East Pye Solar
Statement of Common Ground: Norfolk Wildlife
Trust

Revision 1
October 2026

Planning Inspectorate Reference: EN0110014

Document Reference: EXAM/9.7

Figure 8.3 - Non-Statutory Designated Sites within 2km
 Sheet 5 of 6
 Revision A

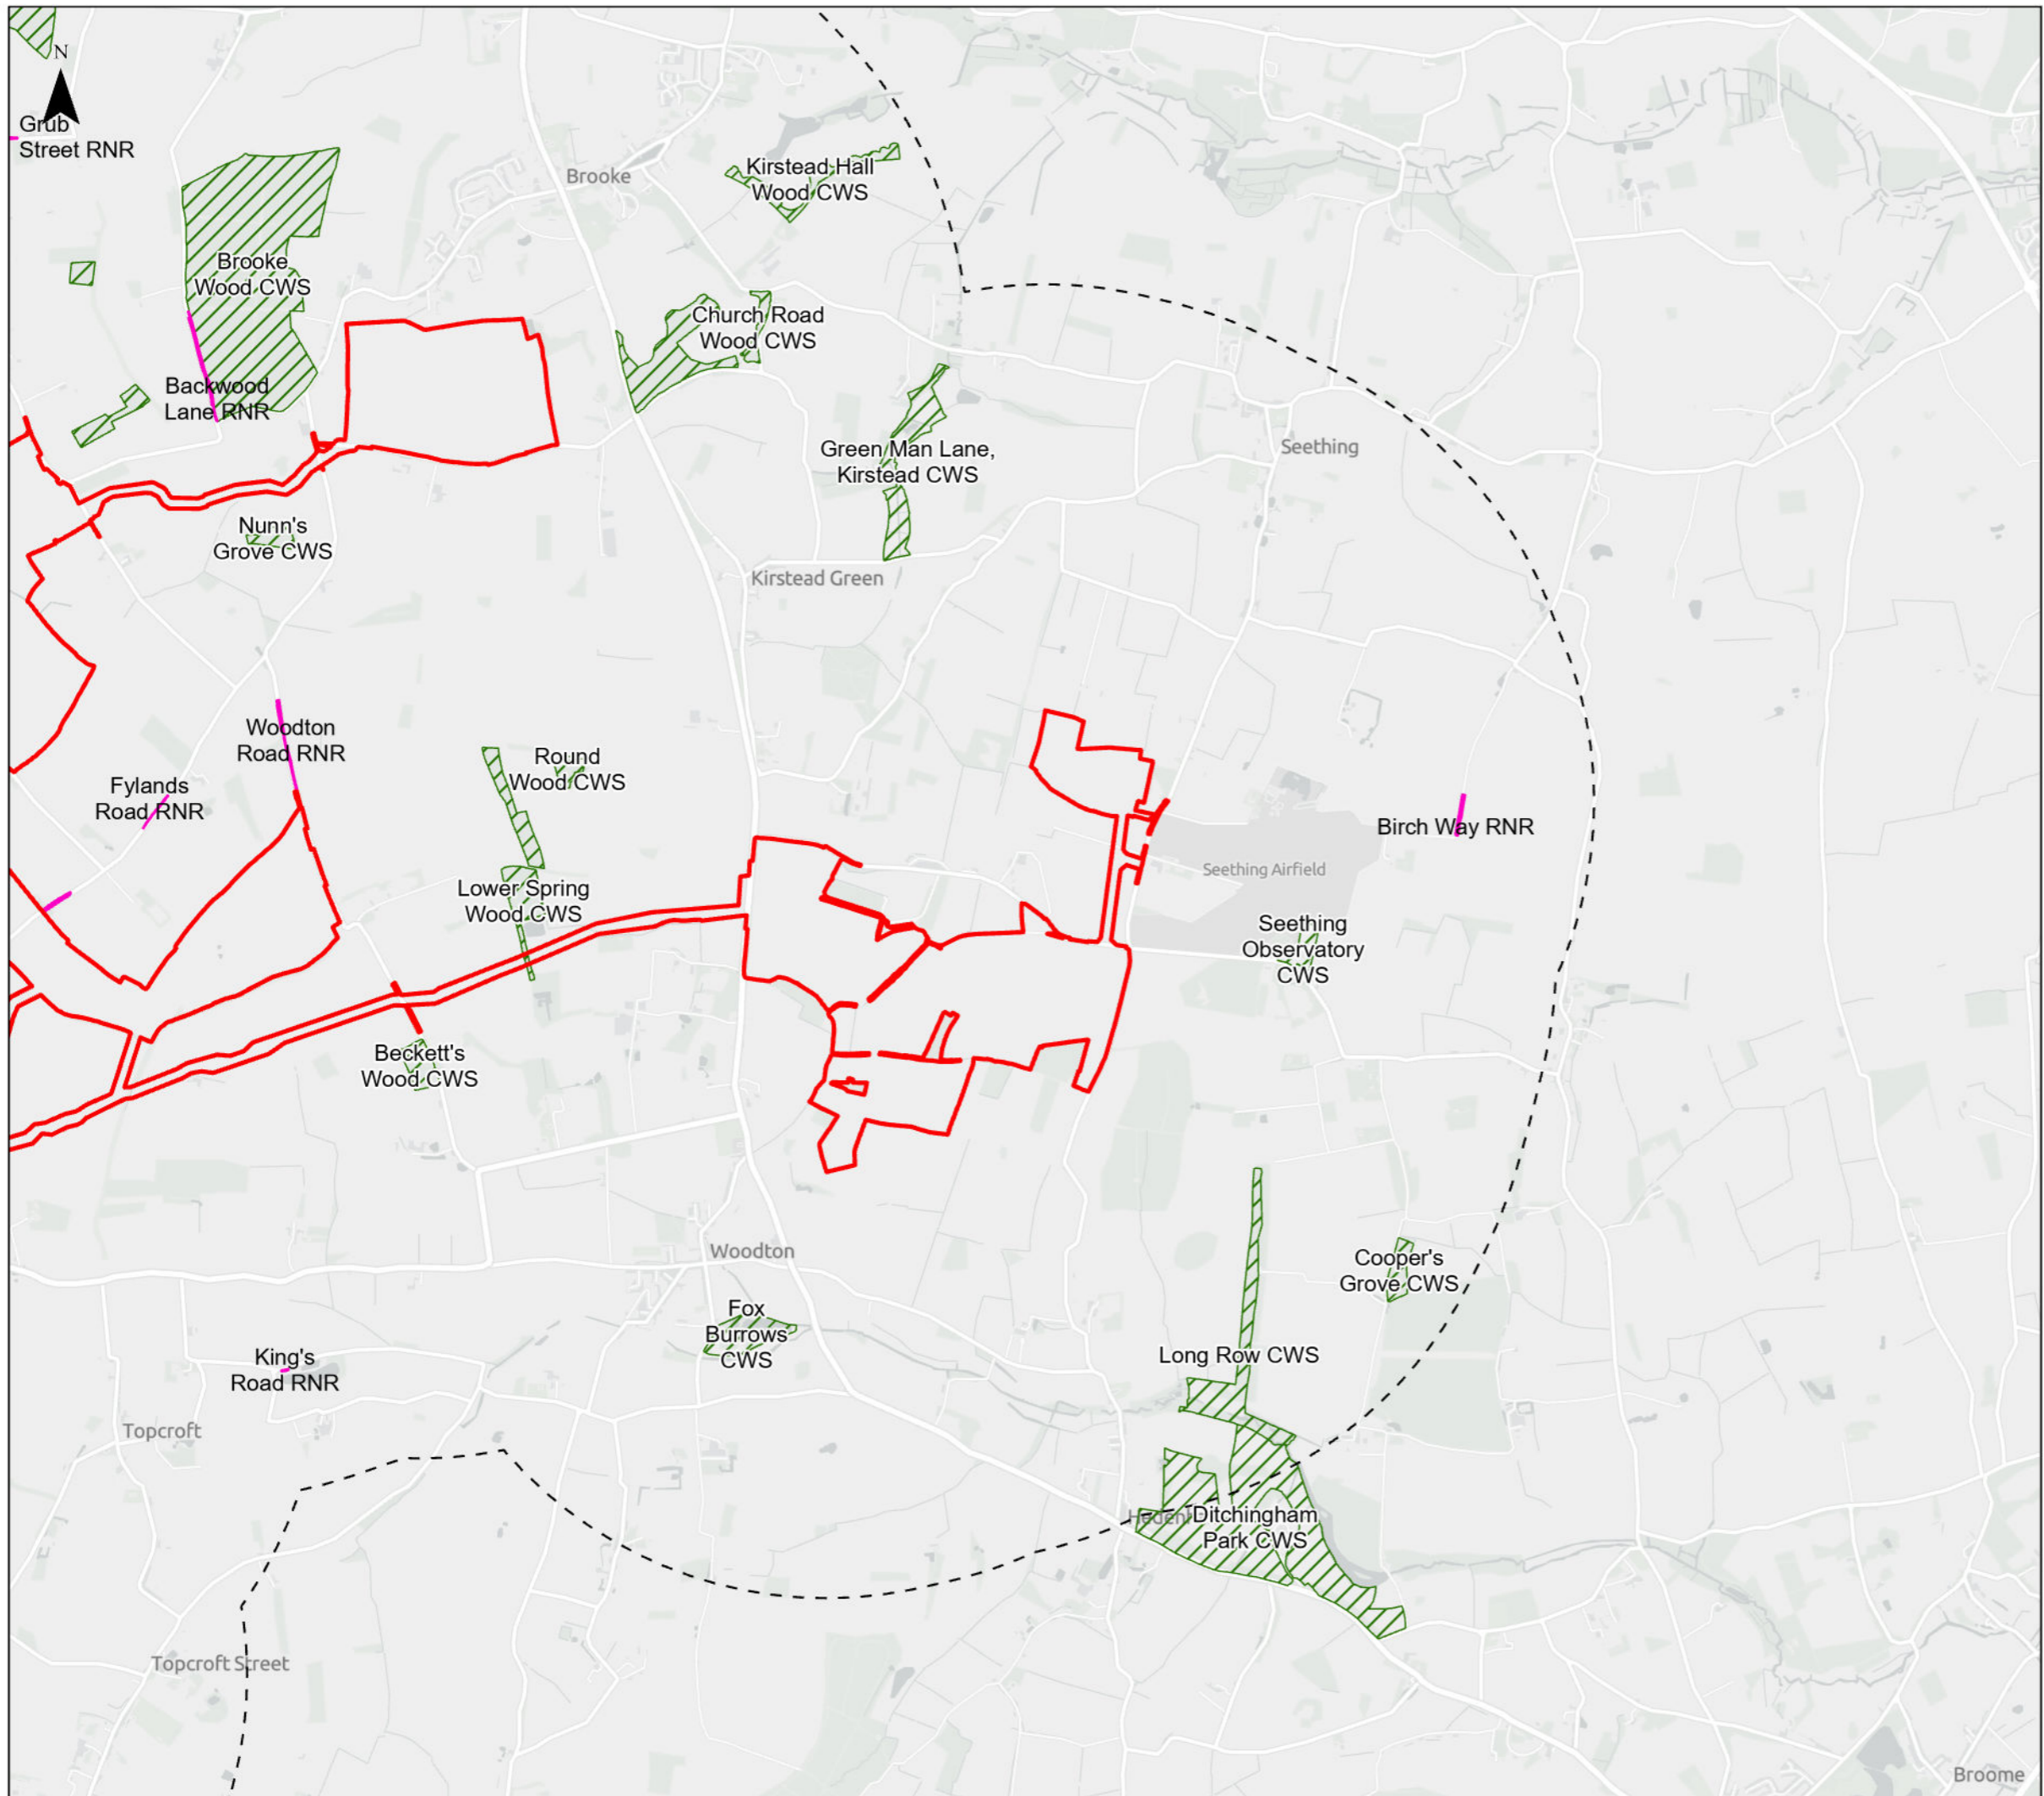
NWT EB - 4	Impacts on County Wildlife Sites and Roadside Nature Reserves	ES Volume 1, Chapter 8 – Ecology and Biodiversity [APP-044]	The Order Limits include parts of two County Wildlife Sites (CWSs) Lower Spring Wood CWS, and Fritton Grange Meadows CWS, and are adjacent/in the immediate vicinity of several others.	The Applicant is satisfied that the assessment set out between paragraphs 8.9.47 and 8.9.109 of ES Volume 1, Chapter 8 - Ecology and Biodiversity [APP-044] , has adequately assessed impacts to	Under discussion

The Order Limits also include or adjoin several Roadside Nature Reserves (RNRs), including Bussey's Loke, Market Lane and Parker's Lane. While the applicant proposes to cross both CWSs using Horizontal Directional Drilling (HDD), critical details remain unresolved. The Outline Construction Environmental Management Plan (oCEMP) confirms that the precise locations of HDD entry and exit points will only be determined at the detailed design stage.	County Wildlife Sites (CWSs) and Roadside Nature Reserves (RNRs). The Scheme has designed out impacts to these sensitive sites through run-off control, pollution prevention and dust control during construction which will be secured by the Outline CEMP [APP-196]. Stand-off distances of 30m from the CWSs and the adoption of Horizontal Directional Drilling (HDD) will mitigate impacts. As per Section 4.4 of the Outline Cable Route Construction Statement [APP-216] the technology used for the HDD will be determined by feasibility studies carried out at each crossing during the detailed design stage and in accordance with a method statement. The embedded design principles adopted and detailed within the Design Principles, Parameters and Commitments [APP-213] have been applied to protect CWS, and commit to specific CWS avoidance areas; this will include HDD entry and exit points.
